Appeal Decision

Appeal Ref: APP/R5510/W/21/3288792

40A Windmill Hill, Ruislip HA4 8PX

Drawing Title
EXISTING AND PROPOSED LOFT,
EXISTING AND PROPOSED rear
ELEVATIONS
Drawn/Design
Scales: AS SHOWN @ A1
Drawing No
PL-103
Date 01/04/21
Rev B

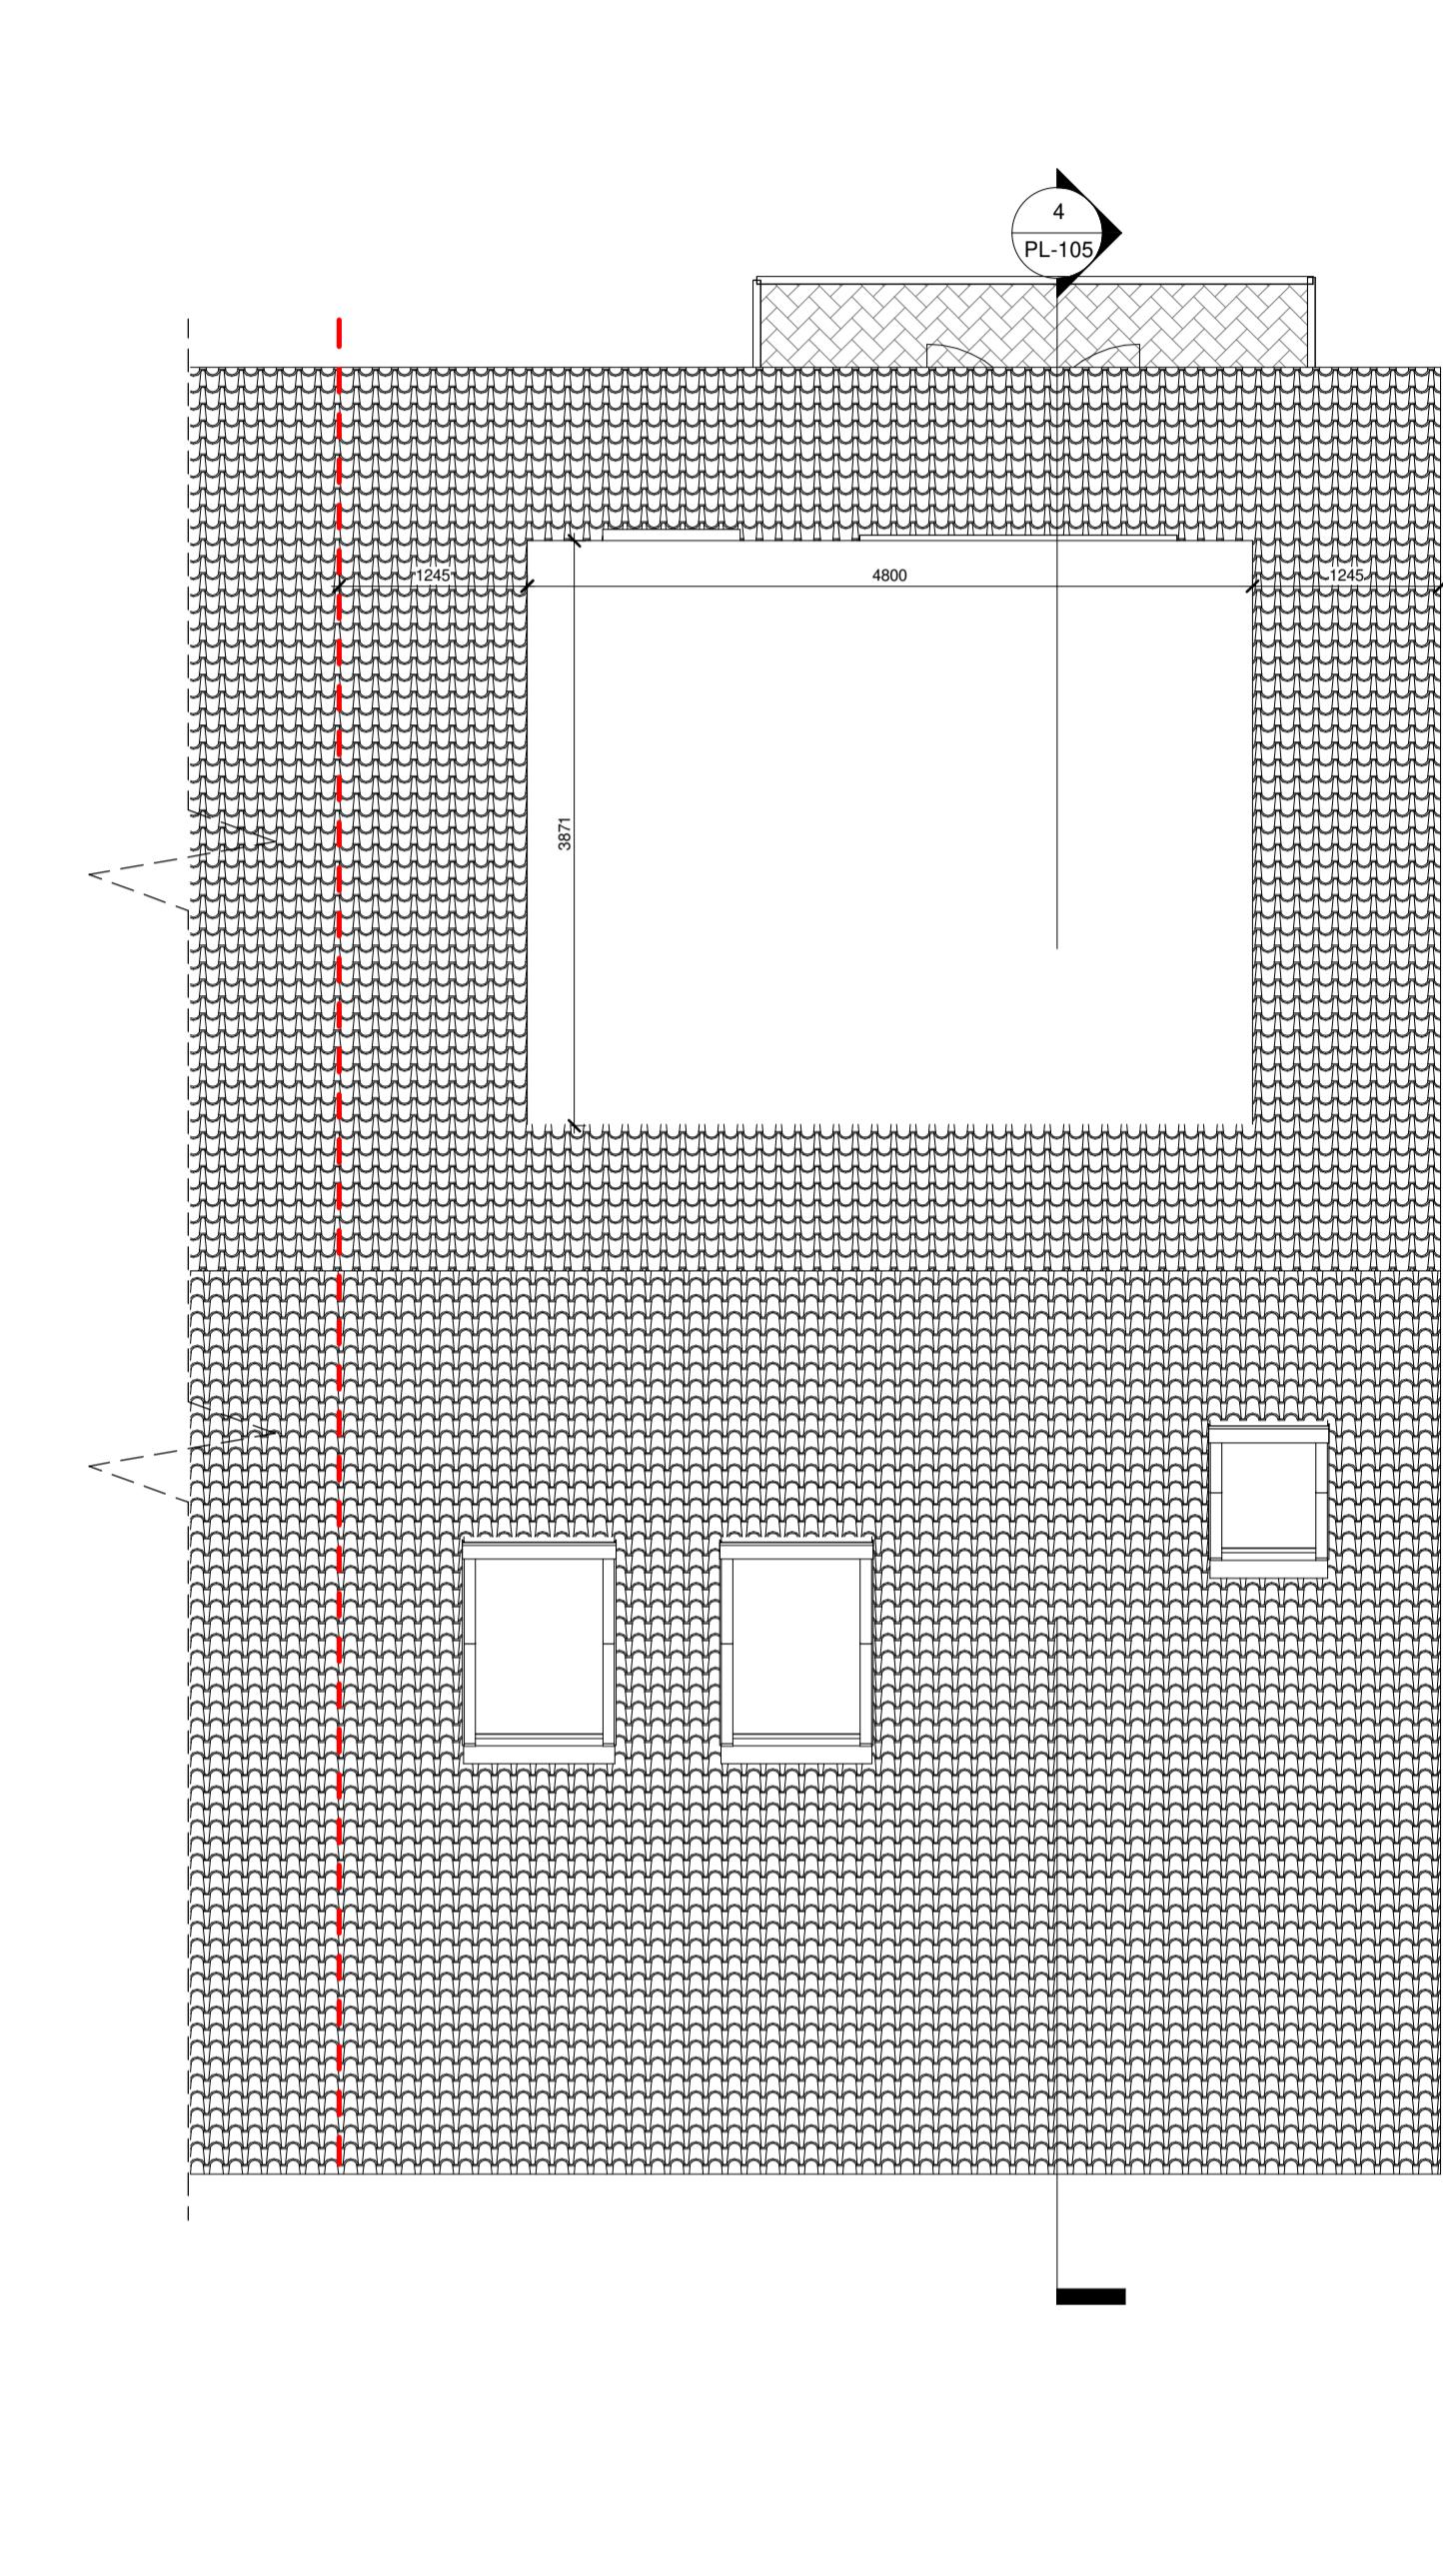
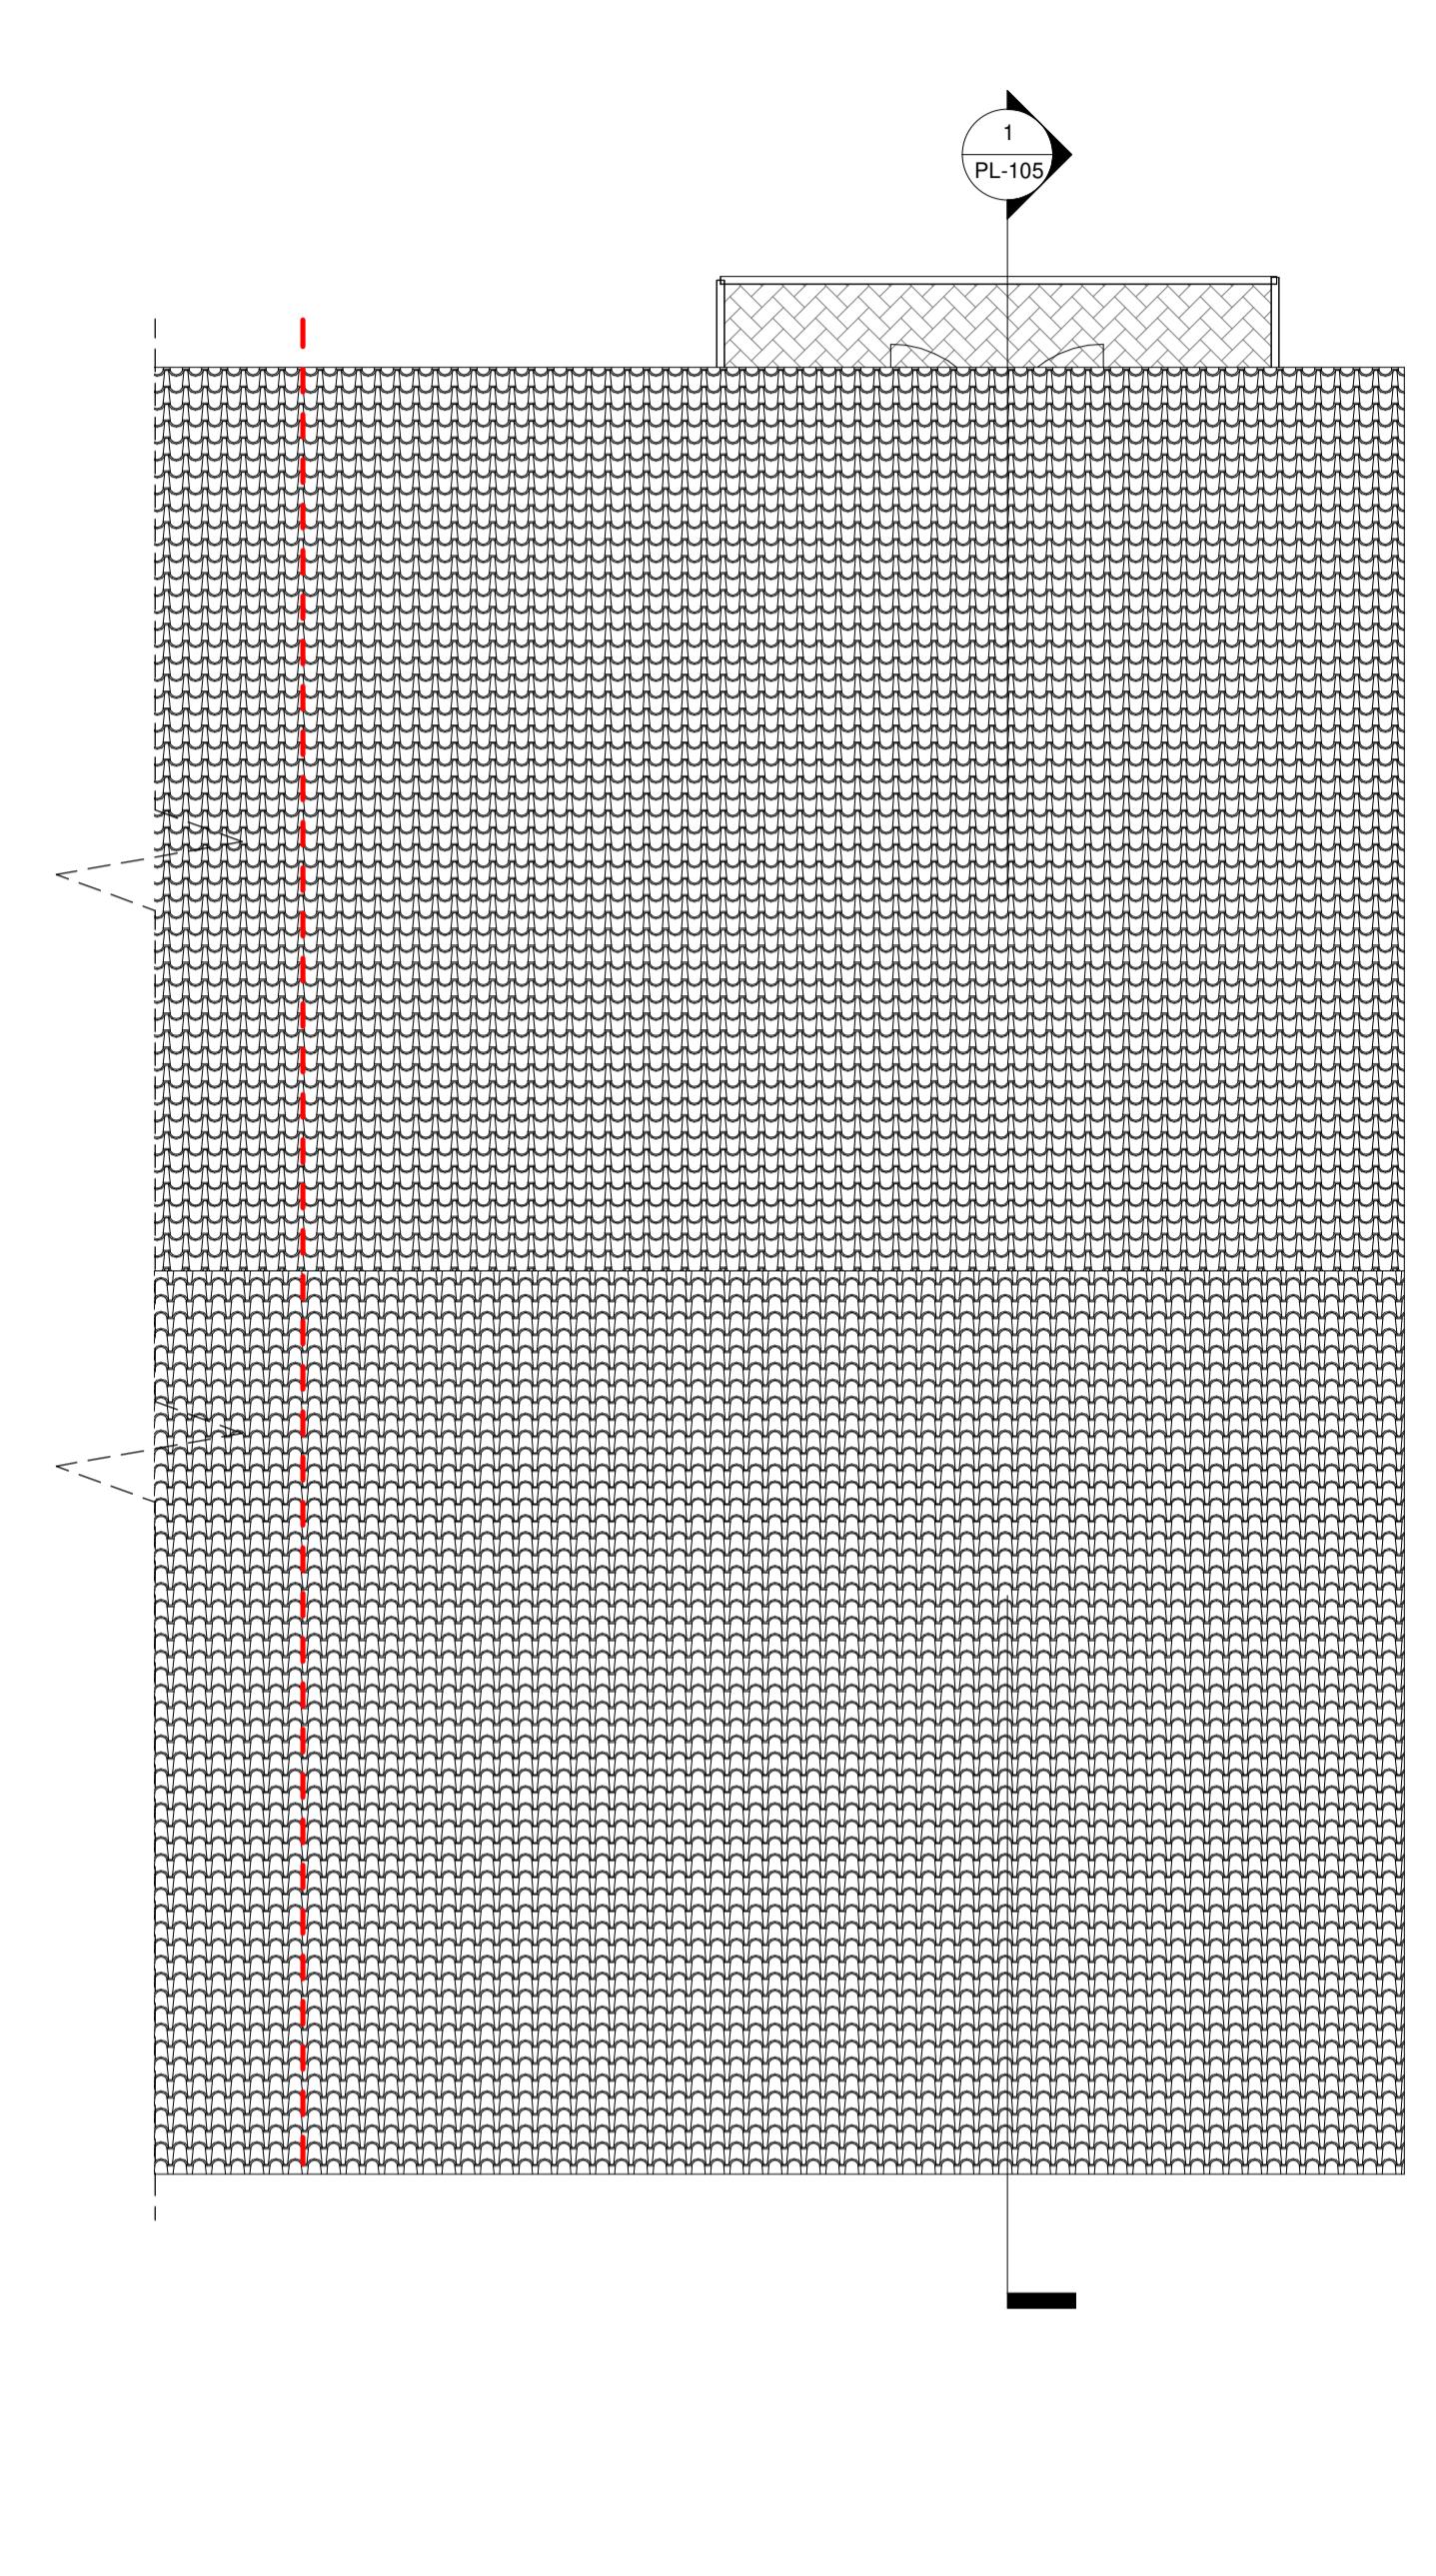
7. In this context, the proposed dormer window would be a substantial and dominant feature within the rear roof slope. Whilst located below existing ridge tiles it would fail to retain a substantial element of the original roof slope of the appeal property and would be neither subservient to the scale of the existing roof of the appeal property, nor to the building as a whole. It would, thus, be an incongruous 'over-large' extension that would fail to respect the otherwise modest proportions and simple design of the existing building or harmonise with surrounding local context.

9. Rather, it is the scale and slab-fronted / sided proportions of the proposed dormer together with its limited insets and set-downs that ensure it would be a disruptive and intrusive roof alteration on an otherwise modestly plan and architecturally simple building. As a consequence the proposed dormer window extension would be excessively scaled and overly large within the context of the appeal property and existing building and would dominate the rear roof slope and rear elevation of the building. Nor would it be truly subservient to the scale of the existing roof slope.
